MEMORANDUM

TO: Nell Donaldson, Planner
FROM: David Senus, P.E.
DATE: March 16, 2015
RE: 195 Kennebec Street, Preliminary Level II Site Plan Application

DRAWN: DED	DATE: 11.25.14
DESIGNED: ADJ	SCALE: 1" = 20'
CHECKED: ADJ	JOB NO.: SP-M160
FILE NAME: SP-M160 BASE	
SHEET: C-4.0

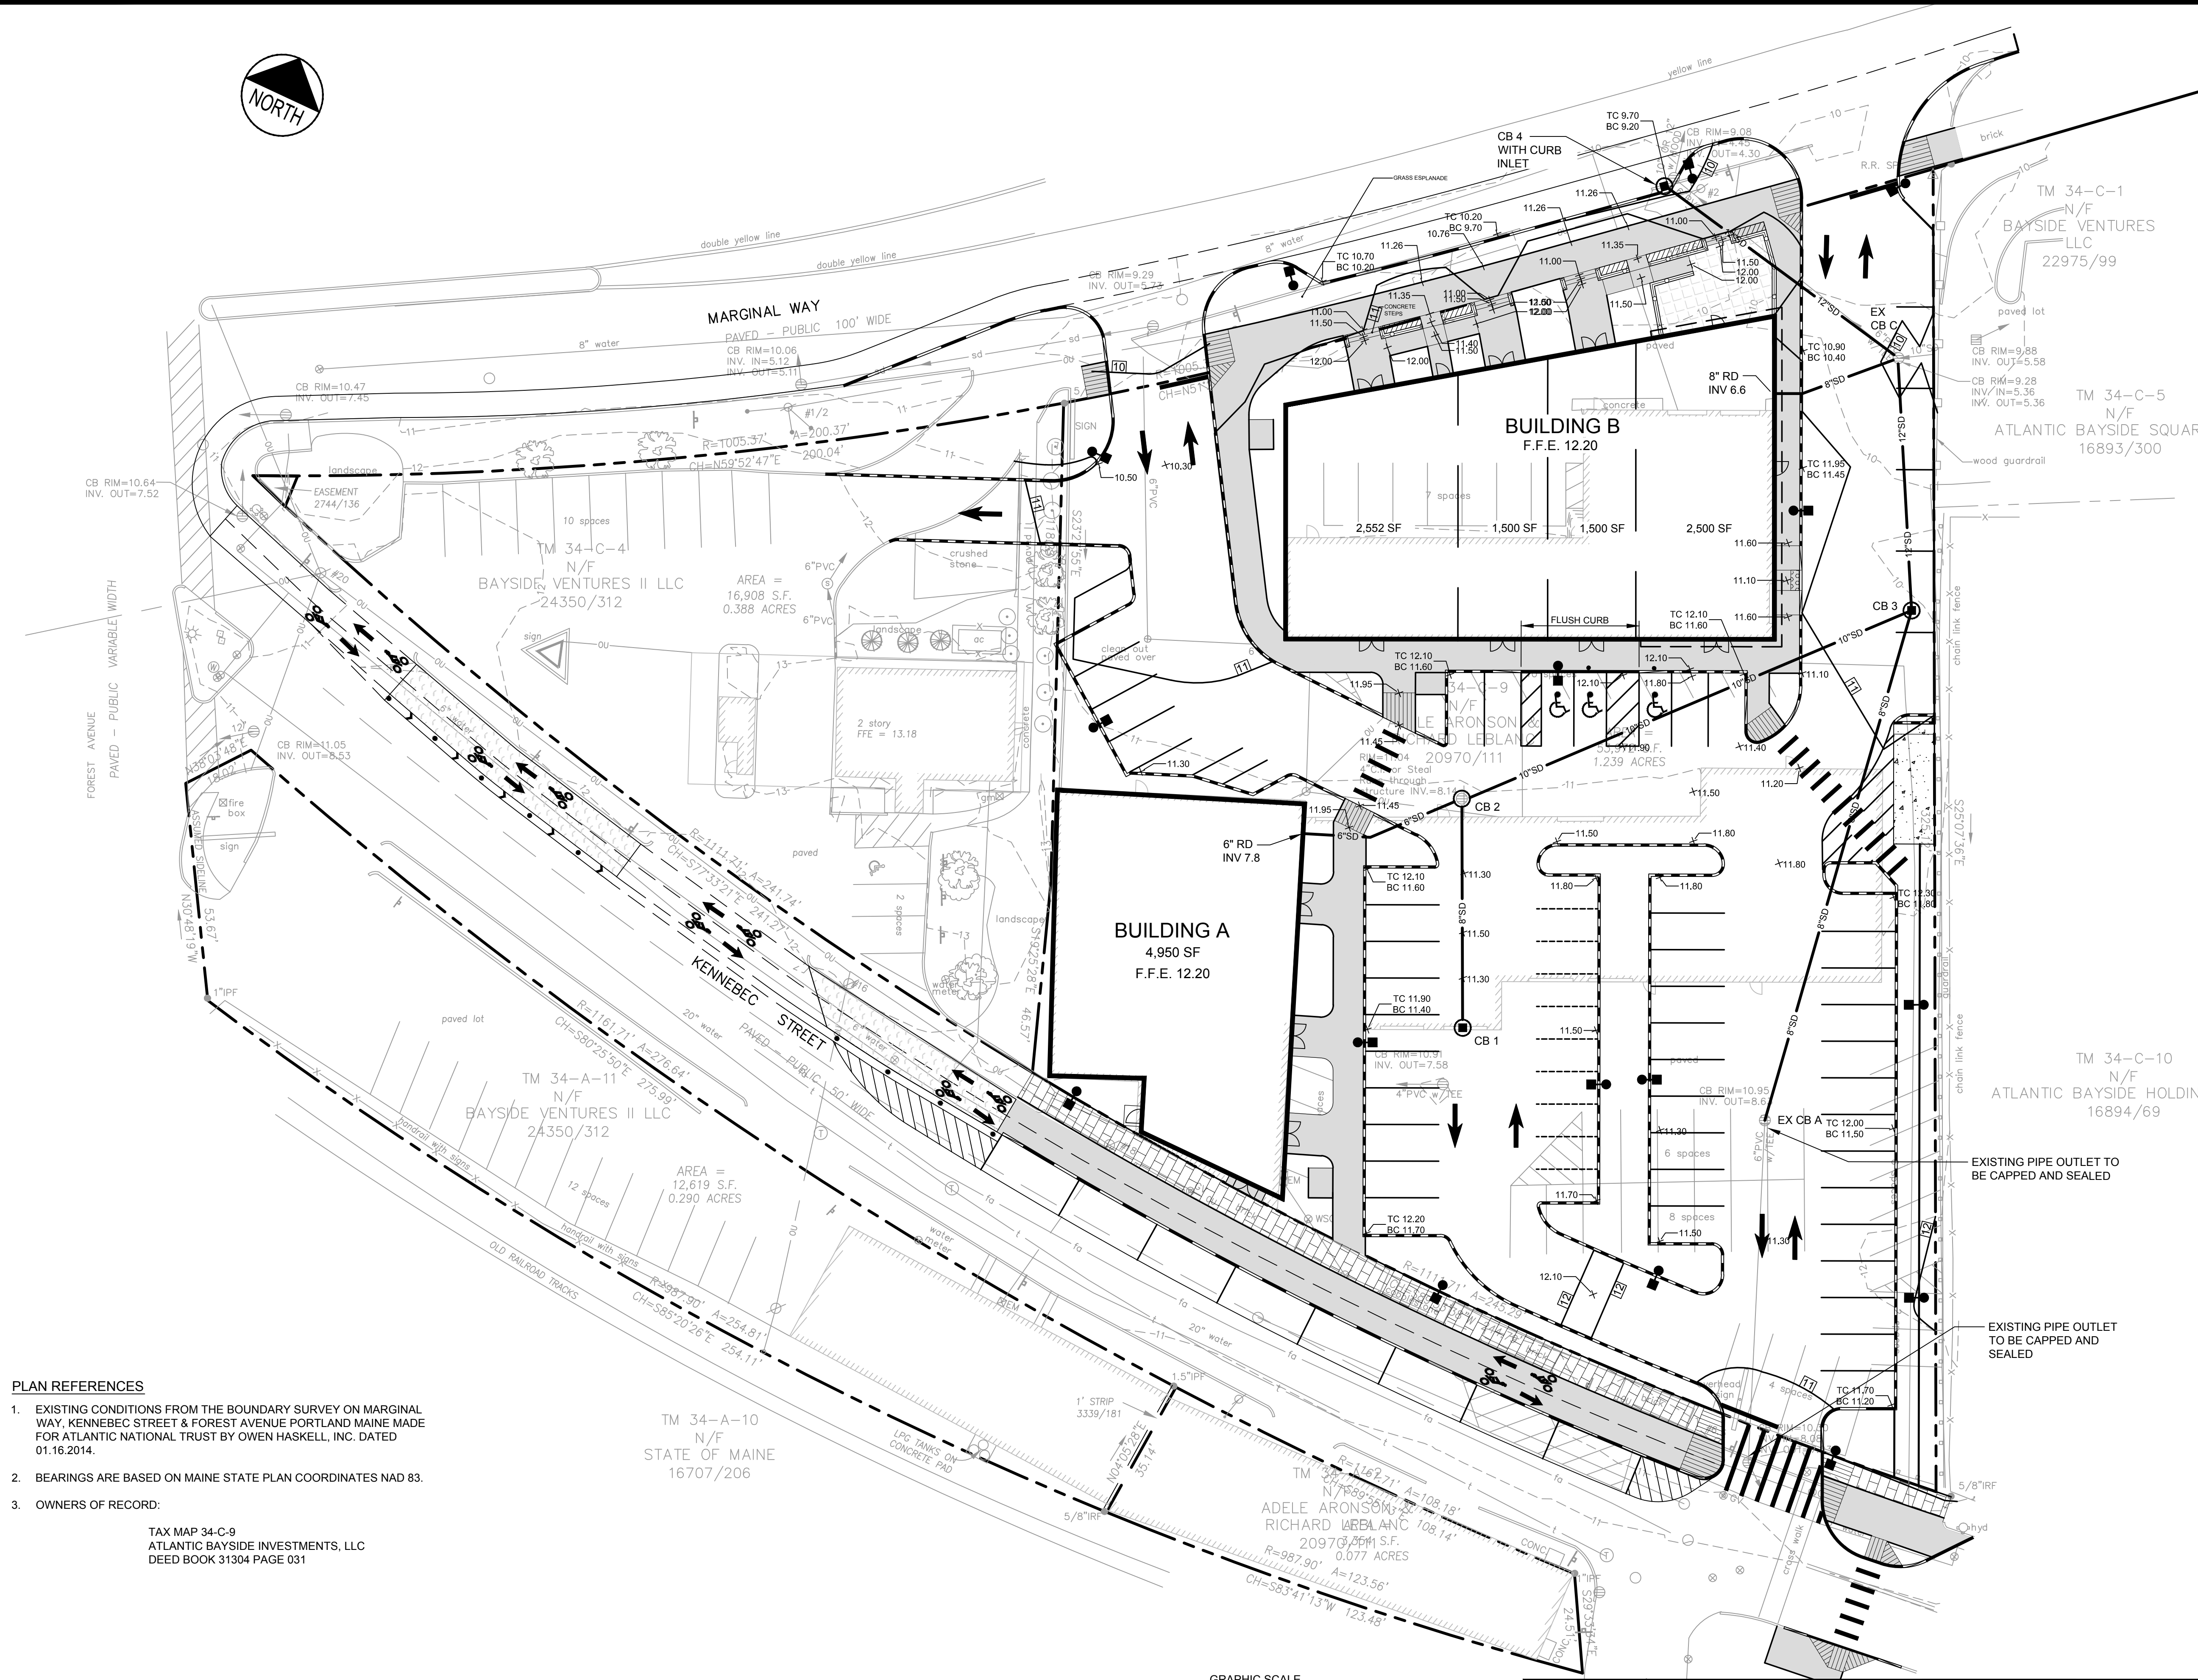
- 2) The Applicant proposes to install a new storm drain collection system for the majority the site that will discharge to a catch basin connected to the combined sewer in Marginal Way. The Applicant proposes to preserve an existing Catch Basin "A" on the south side of the site, which connects to the Kennebec Street combined sewer system. The City anticipates installing a new, separated storm drain system in Marginal Way in the coming years; as such, the City requests that existing Catch Basin "A" be connected into the proposed system discharging to Marginal Way.
